CITY OF MERCER ISLAND

August 2, 2019

RE: SUB19-002/SEP19-005 – 14-lot long subdivision proposed at 2825 W. Mercer Way
First Review & Request for Information

3/1/19
 JOB NUMBER:
13-118
 SHEET NAME:
SP-01
 SHT **3** OF **9**

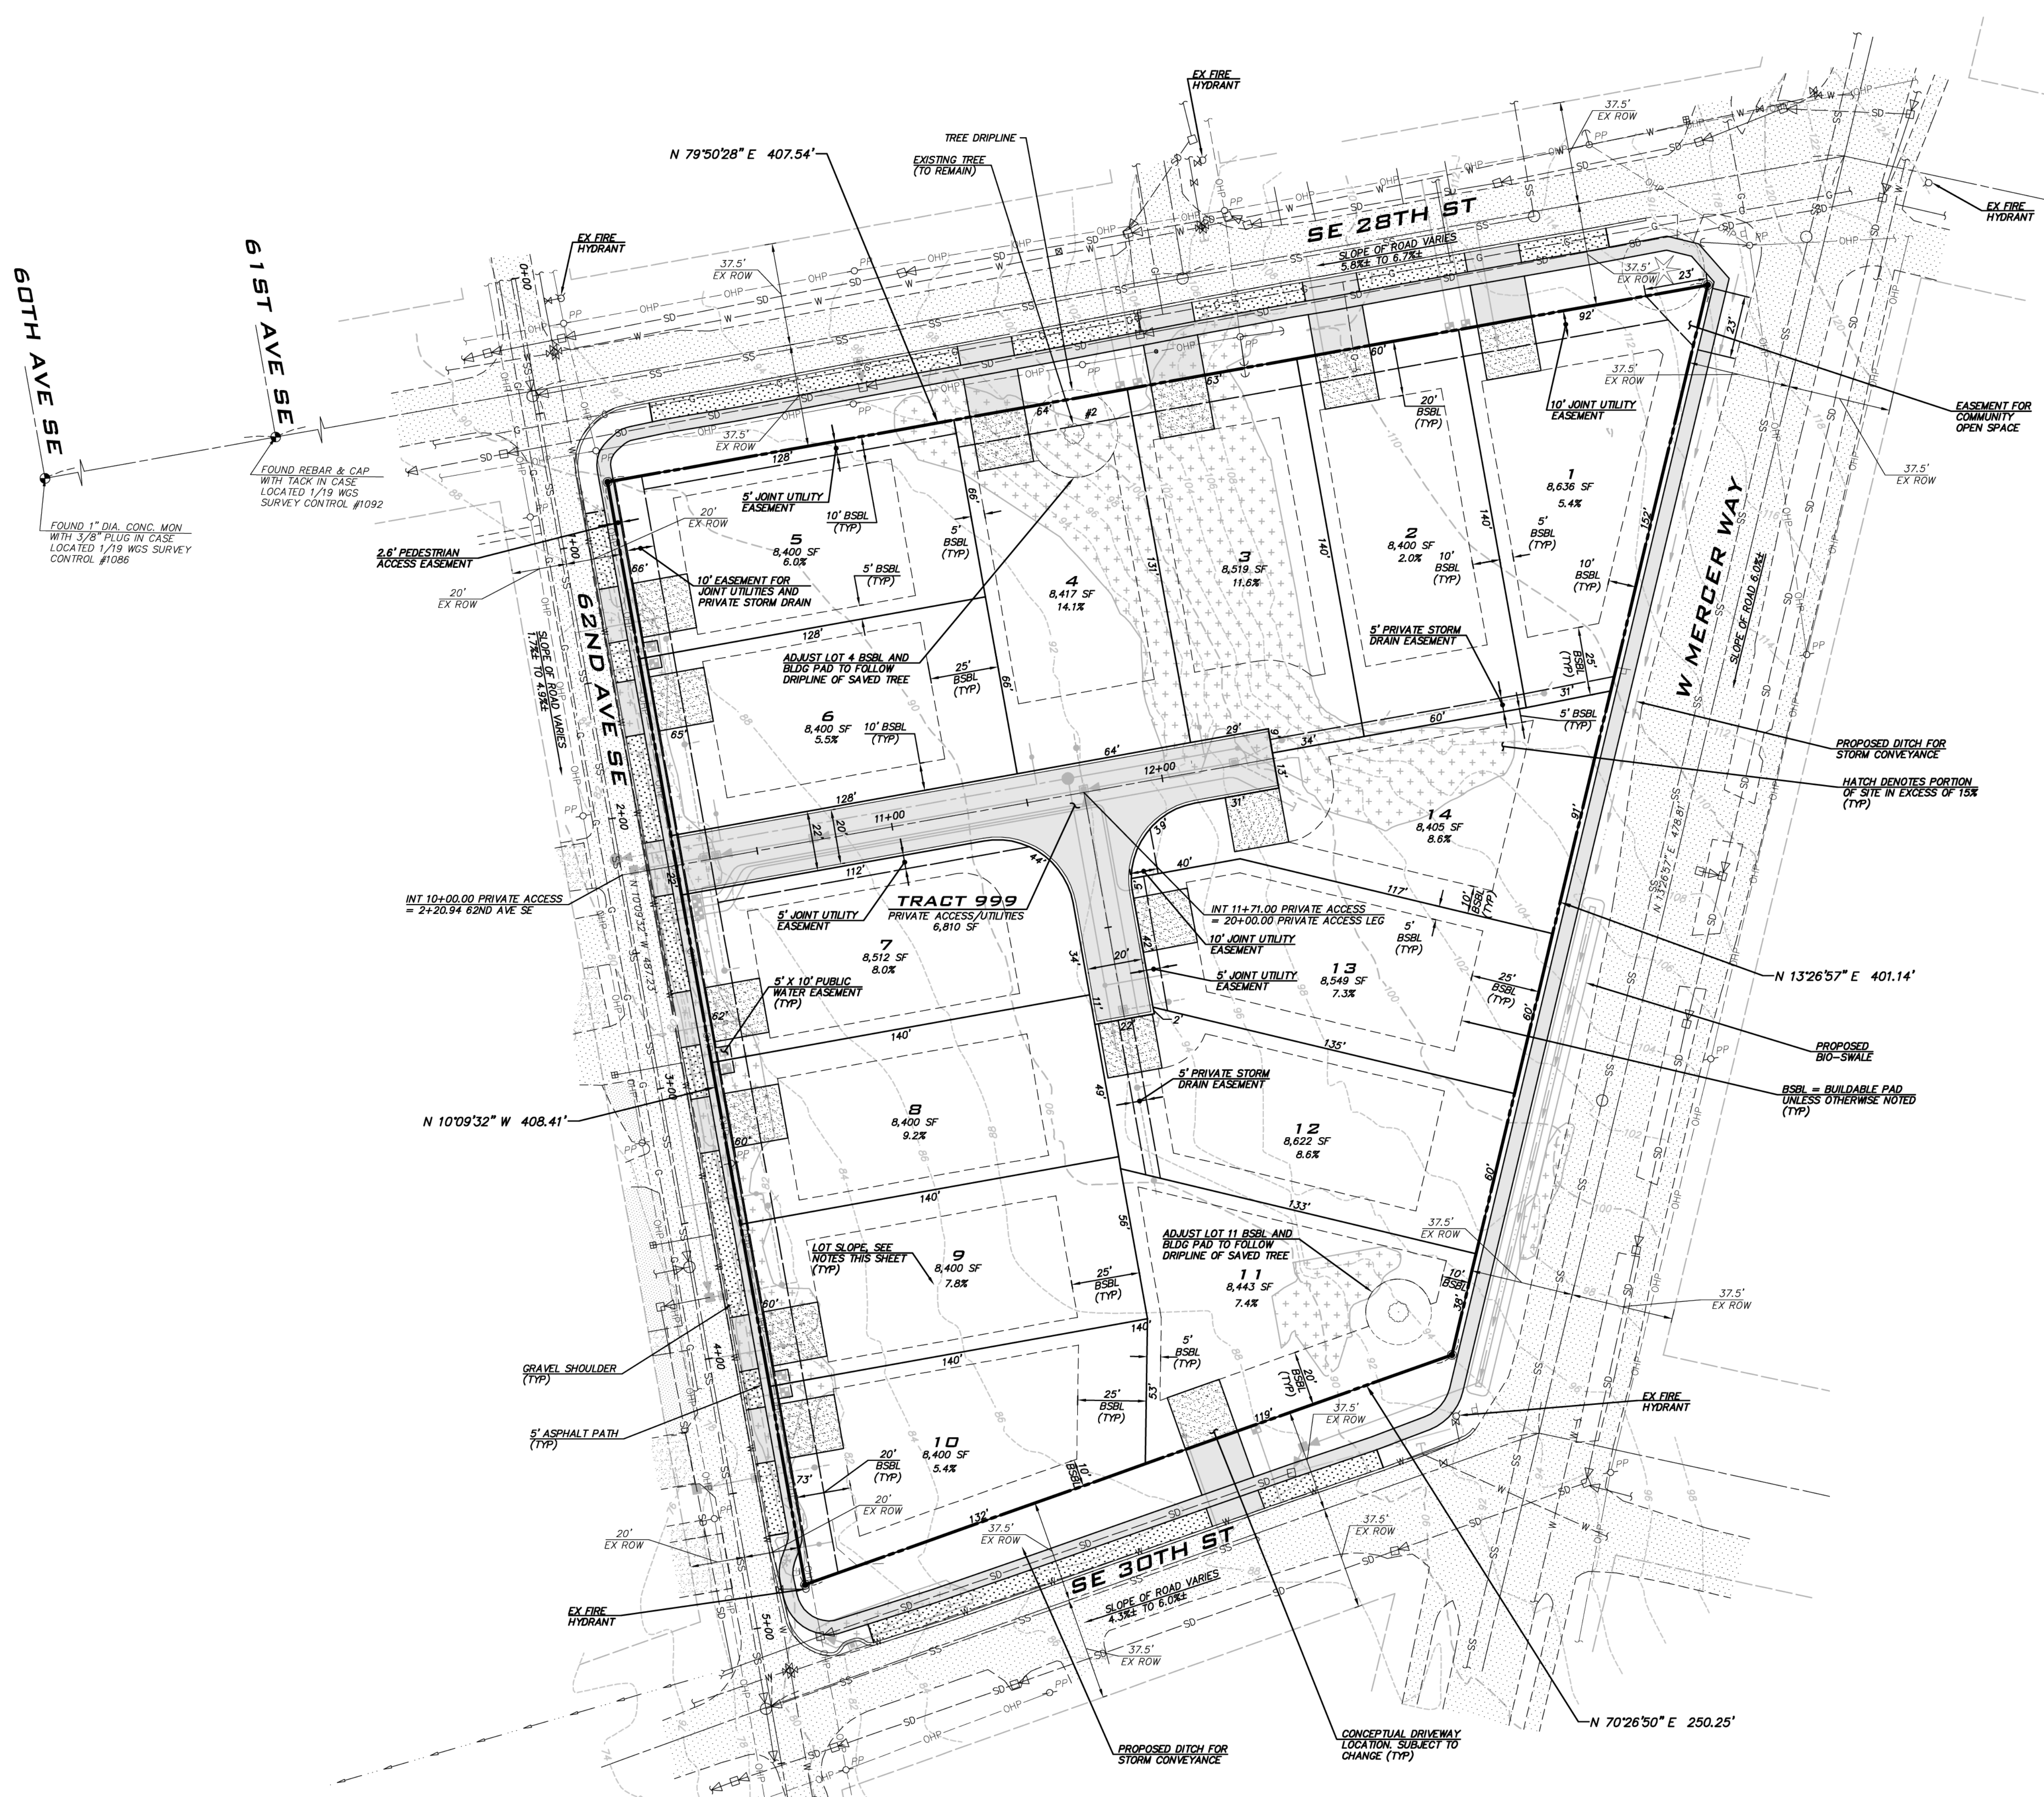
2. Sheet 3 - Demonstrate Tree #2 is sufficiently protected (will survive) with 16 feet of protection. Building pad, driveway, wall and associated grading will need to be shown outside this protection area. This means showing at least 5-ft of space between building pad and driveway in addition to the 16-ft protection area. Also, the building footprint should be revised to reflect a more accurate footprint, which may require a longer driveway and smaller house footprint.
3. Chain link fence shall be used to protect all saved trees at their dripline. This will be required to be demonstrated on the site development plan. Please enlarge the notes on the detail provided on Sheet 8 provide a note on Sheet 8 to this effect.

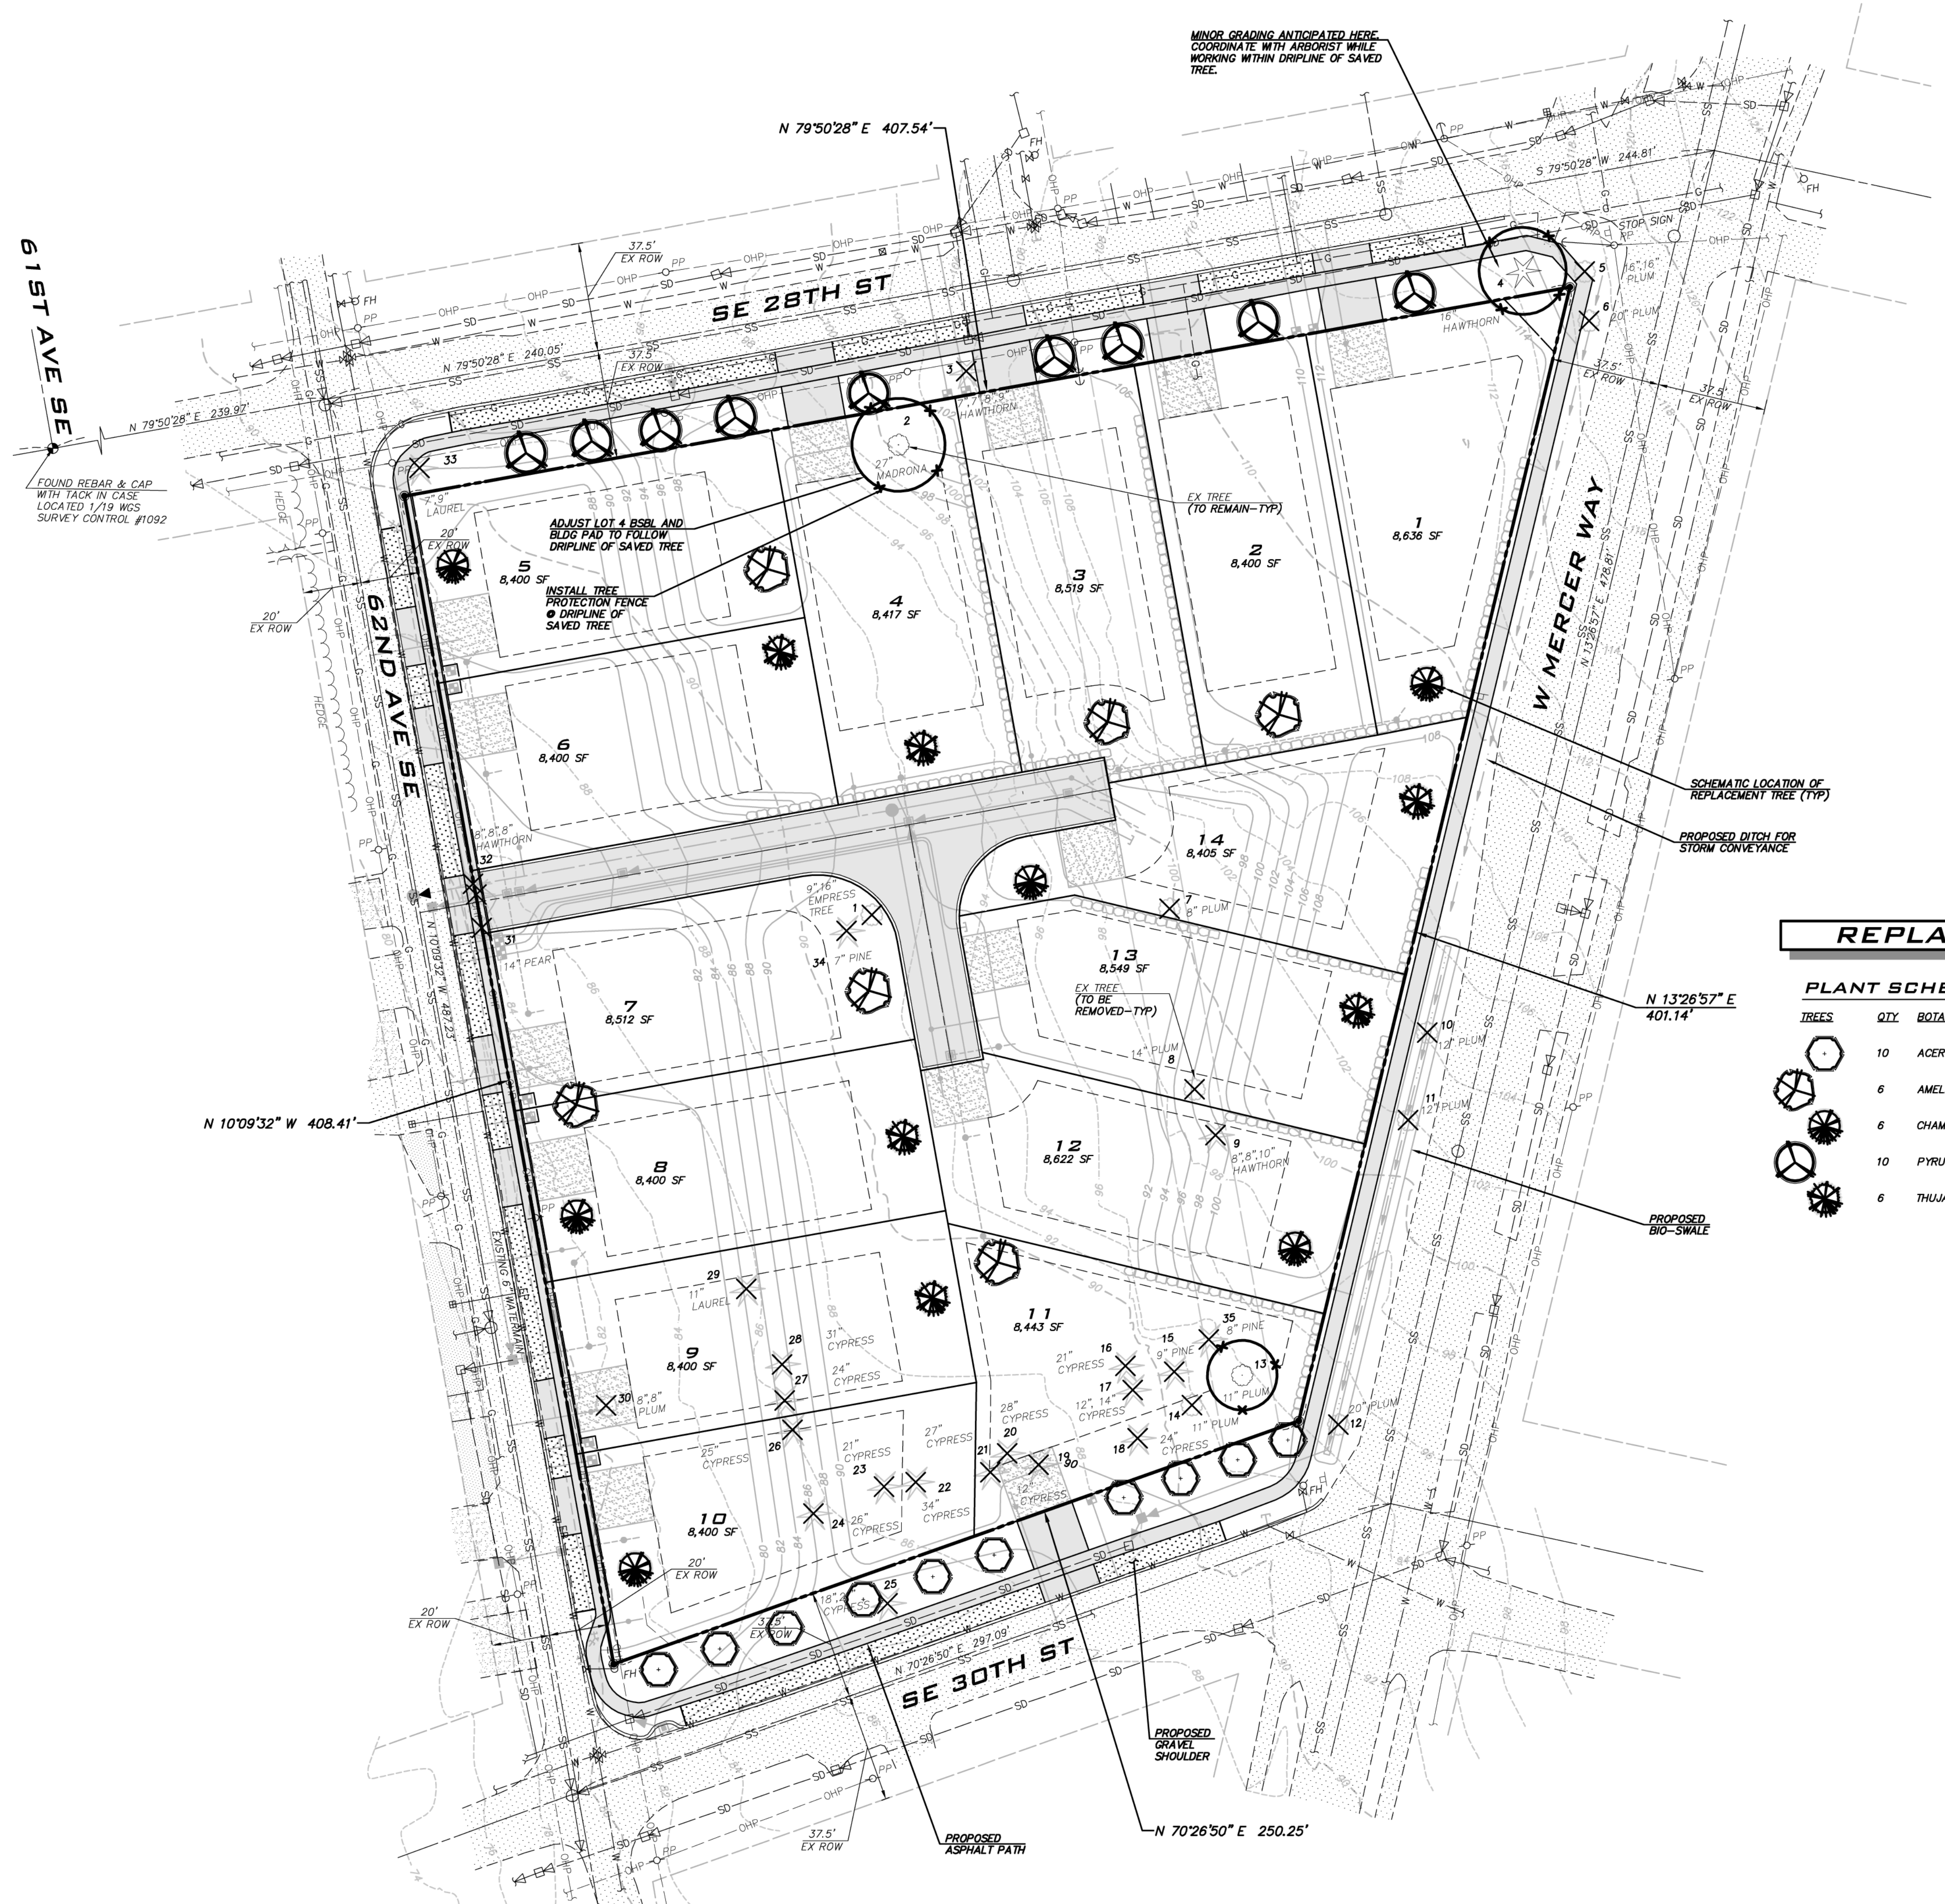
1. Sheet 9 - Only include viable regulated trees in the calculations. Please update the Tree Inventory and Replacement Submittal Sheet to address the following:

- Under Large Regulated Trees section, only include viable trees over 10". The Leyland Cypress and Portugal Laurels will not be regulated on private property and do not need to go in this section.

- Update and confirm at least 30% of regulated trees are retained and protected.
 - Update planting requirements based on viable trees removed.
 - Non-viable trees will not need to be retained, but will need to be replanted. Please demonstrate this has been accounted for.

- Trees #4 and #5 are exceptional by size, but determined to be non-viable. Have your project arborist assess the trees for risk and likelihood of longevity. Update replanting ratio of both these trees at 6:1 ratio.

- Include Tree #25 in right-of-way tree section. This tree must be retained and utilities installed around it. Please demonstrate how this will be accomplished.

- Confirm plans and arborist report match with tree numbers. For example, trees 34 & 35 are listed on the plans but not on the report. They are not regulated and can be removed from the plans.

TREE PROTECTION DETAIL
NOT TO SCALE

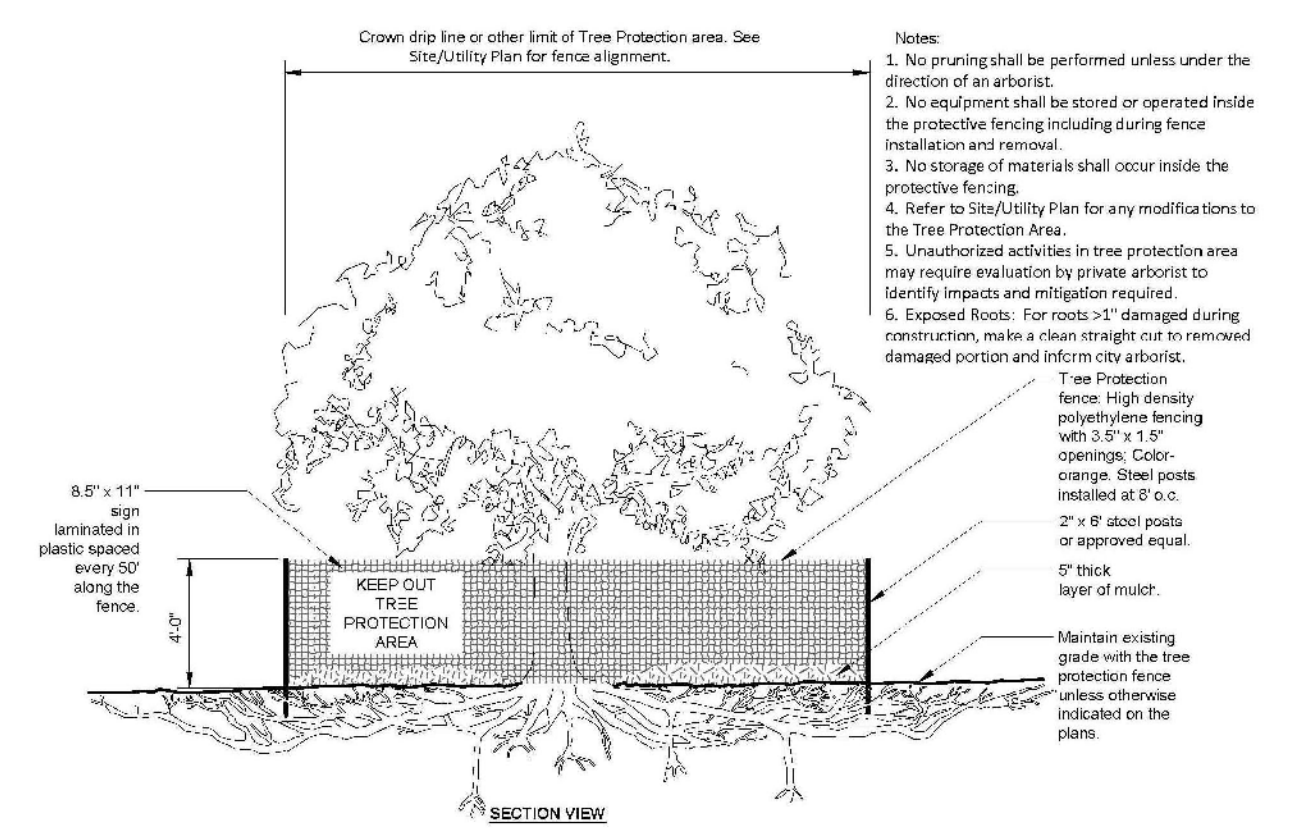
8. Correct the zoning to R-8.4. Other minor comments are provided on the plans, particularly around the tree protection detail for signage and fencing. Please address all review notes.
